REQUEST

Current Zoning: UR-2(CD) (urban residential, conditional) and NS (neighborhood services)
Proposed Zoning: MUDD-O (mixed-use development, optional)

Approximately 7.0 acres located on the northeast corner of Prosperity Church Road and Old Ridge Road.

The petition proposes to allow 79 single-family attached residential units, 15,000 square feet of commercial uses, and a remote drive-through service terminal for a financial institution.

RZ-1

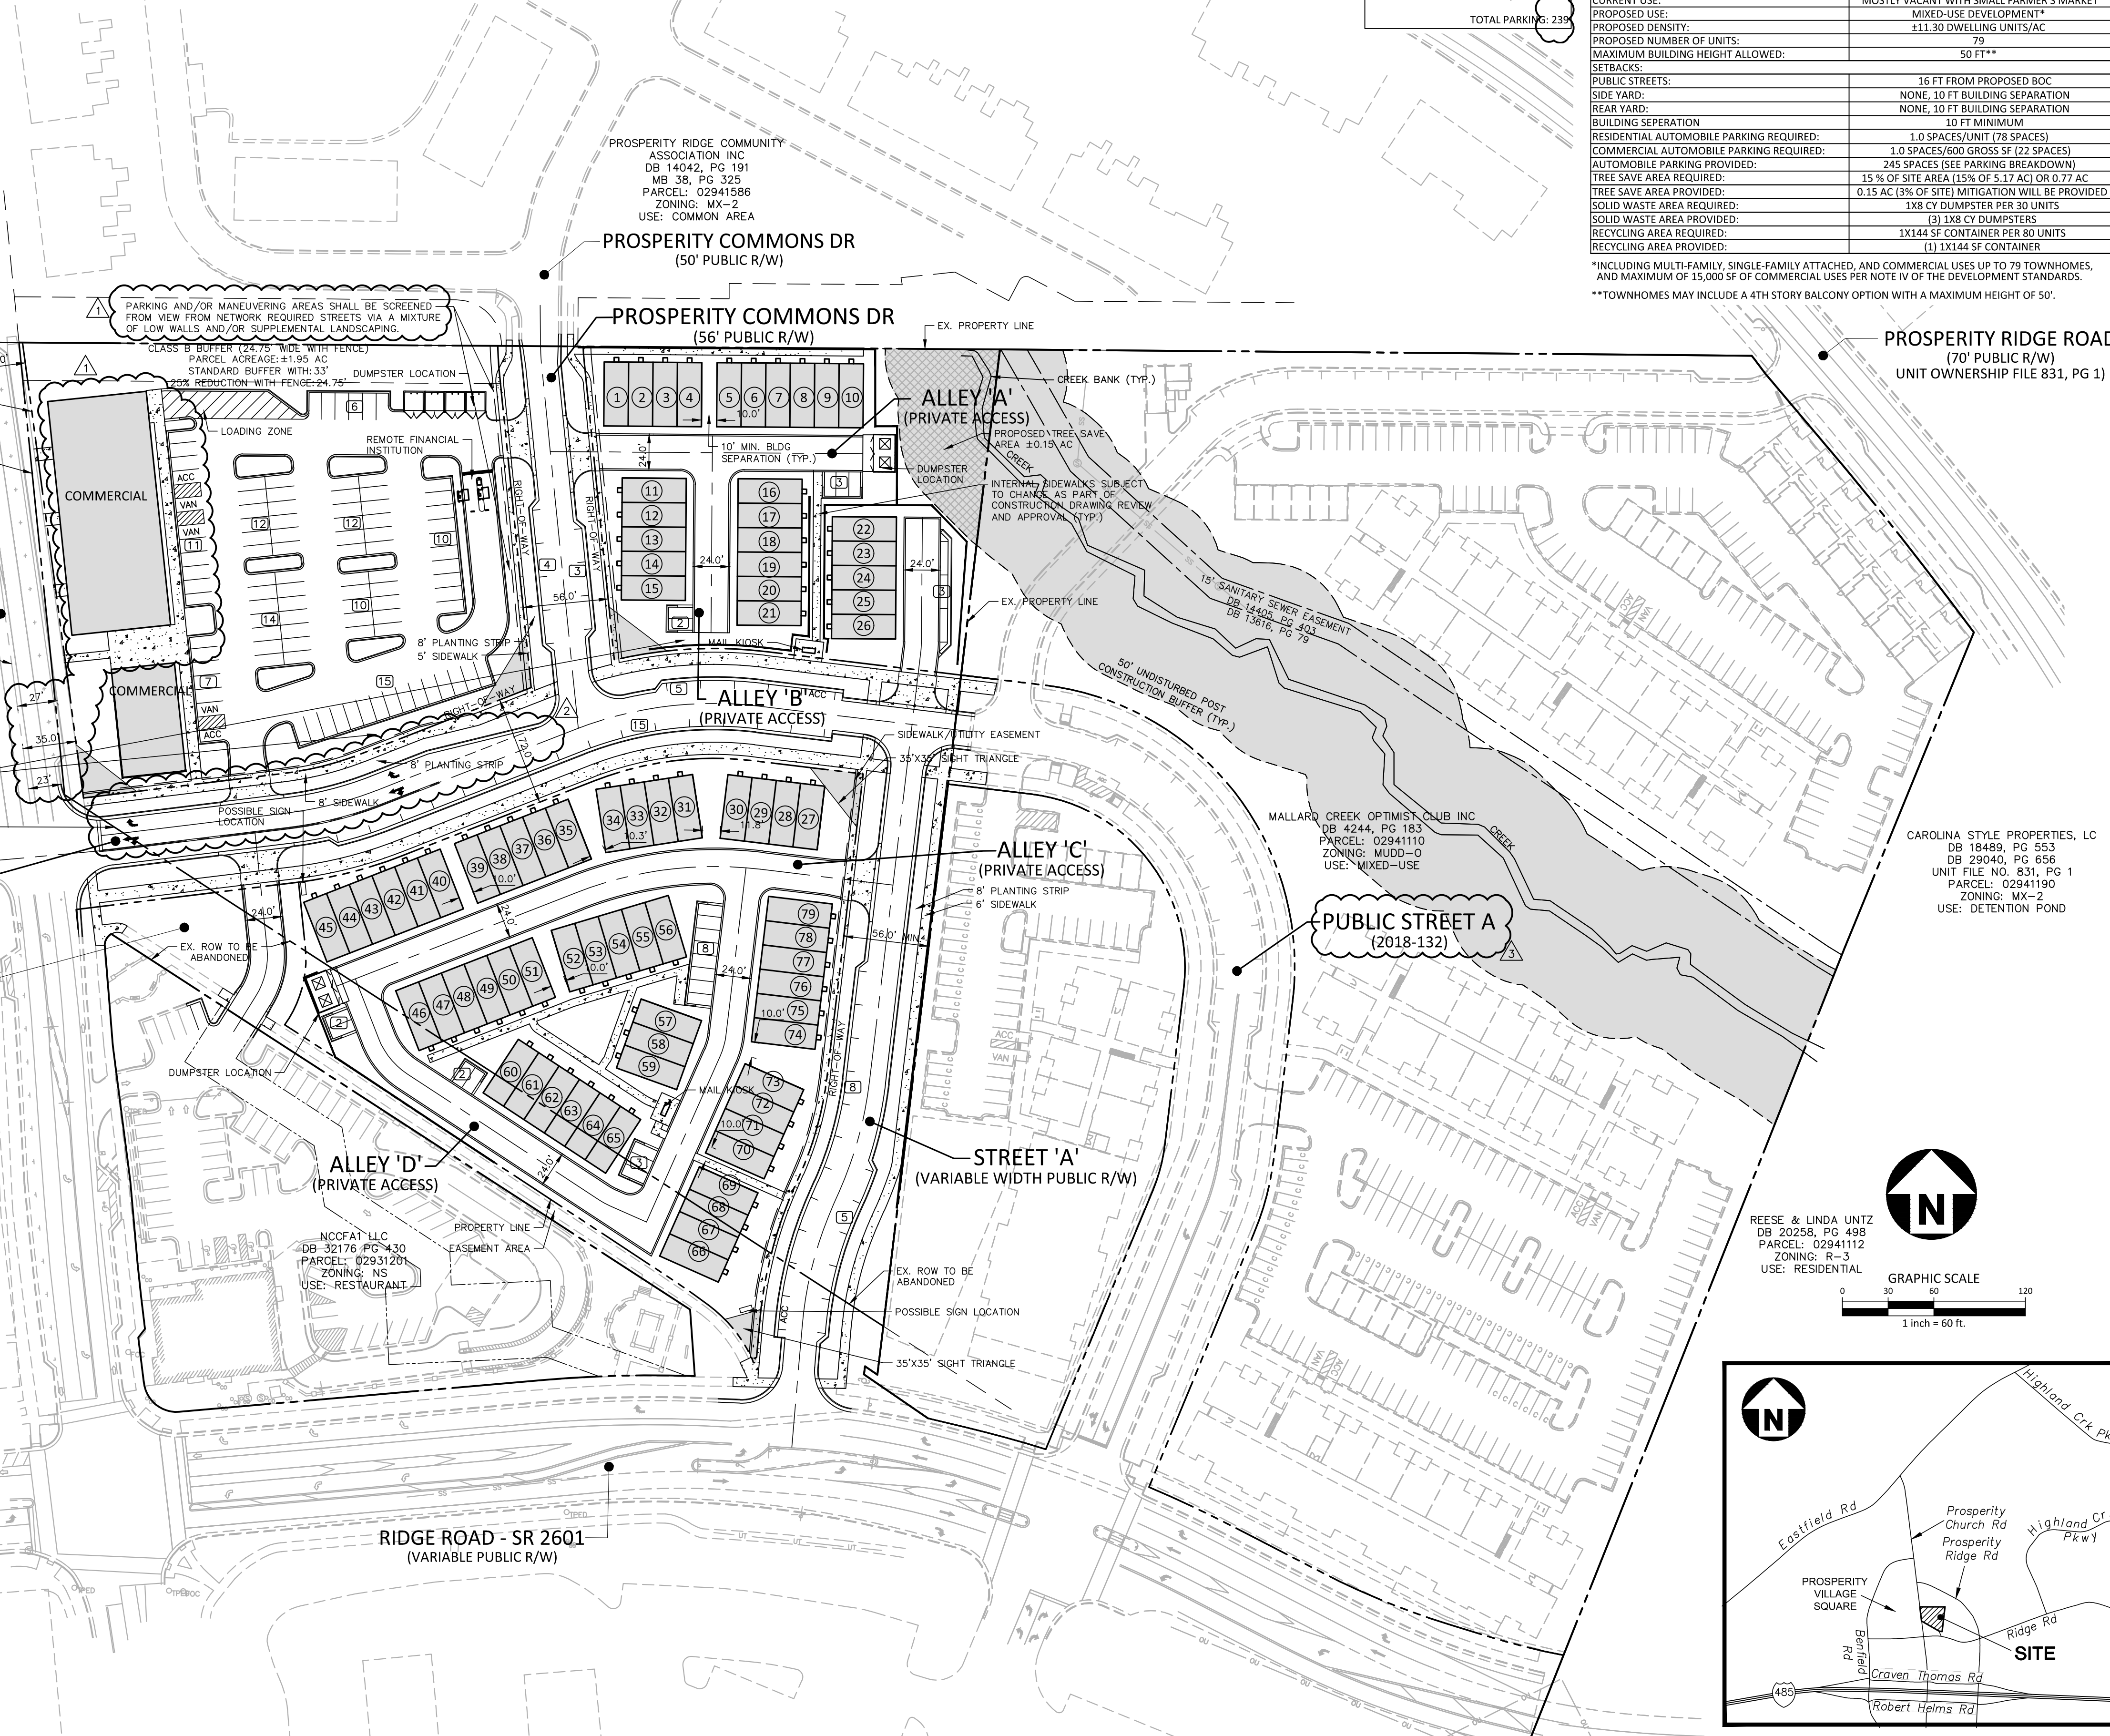
1. ~~The petitioner should revise the site plan and conditional note(s) by removing the note stating the curb and gutter along Prosperity Church Road will be constructed by the City project. The petitioner should commit to construct the required ordinance curb and gutter requirement and streetscape along its frontage of 8-foot planting strip and 6-foot wide sidewalk.~~ **Addressed**
